Revised 4-24-84 per City Inspector
Revised 4-23-84 per MEP-1

WATER PLAN & PROFILE CONCOURSE PLAZA CITY OF ADDISON, TEXAS RAYMOND L. GOODSON JR., INC. 10,200 N. CENTRAL EXP. BLDG. I SUITE 200 DALLAS, TX 75231 214-734-8100						
DESIGN	DRAWN	DATE	SCALE	NOTES	FILE	NO.
RLG INC.	RLG INC.	4-17-84	1"=20'H 1"=6'V		84-339

WATER PLAN & PROFILE						
CONCOURSE PLAZA						
CITY OF ADDISON, TEXAS						
RAYMOND L. GOODSON JR., INC.						
10,200 N. CENTRAL EXP. BLDG. I, SUITE 200						
DALLAS, TX 75231						
DESIGN	DRAWN	DATE	SCALE	NOTES	FILE	NO.
RLG	RLG	4-17-84	1"=20'H 1/8"=6'V

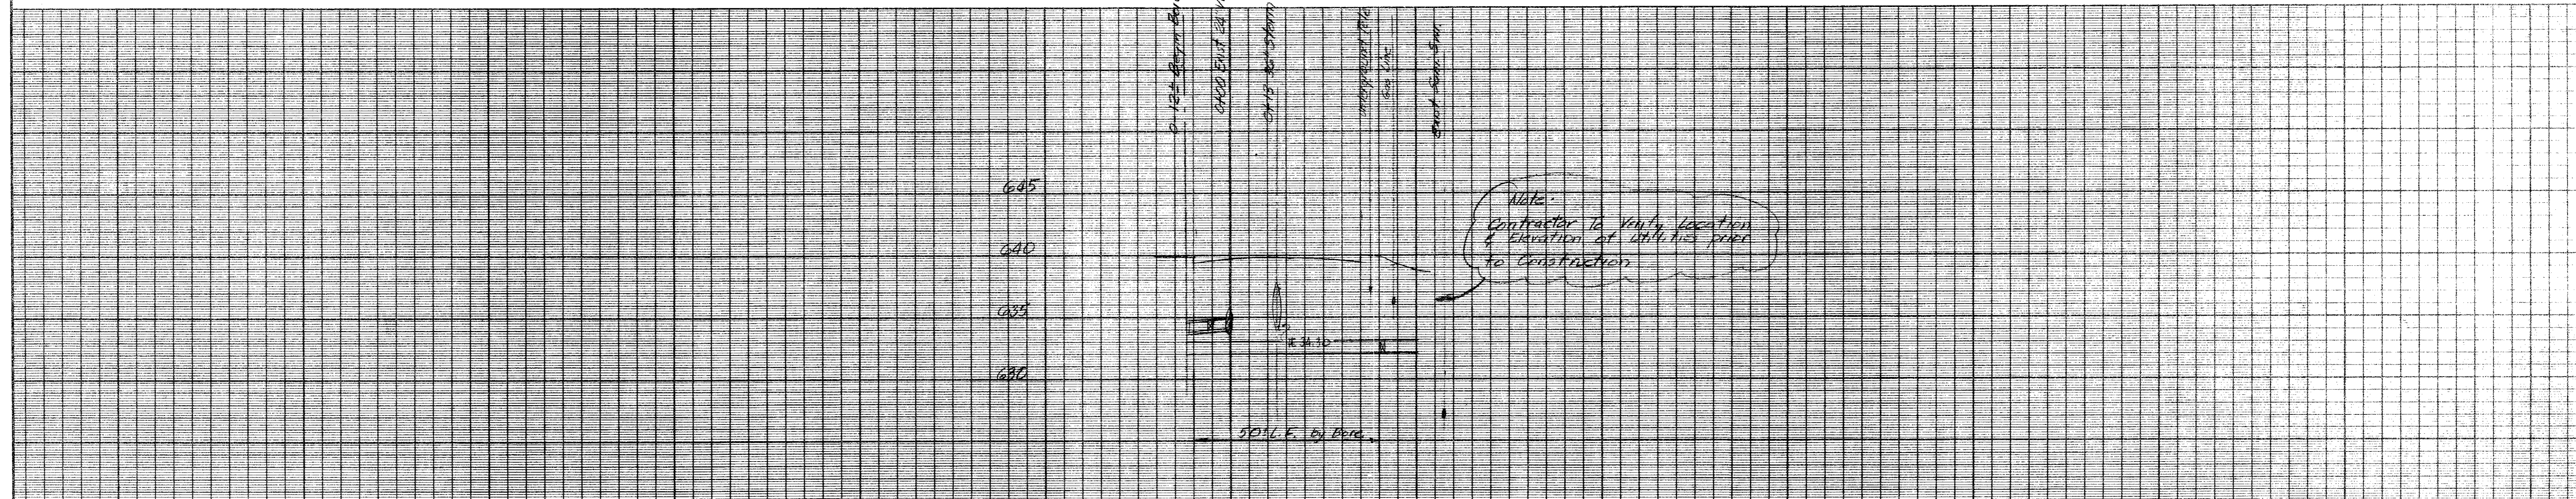
SHOW TRAFFIC BARRETTES

PVMT. REPAIR AT BORE PIT & TAP
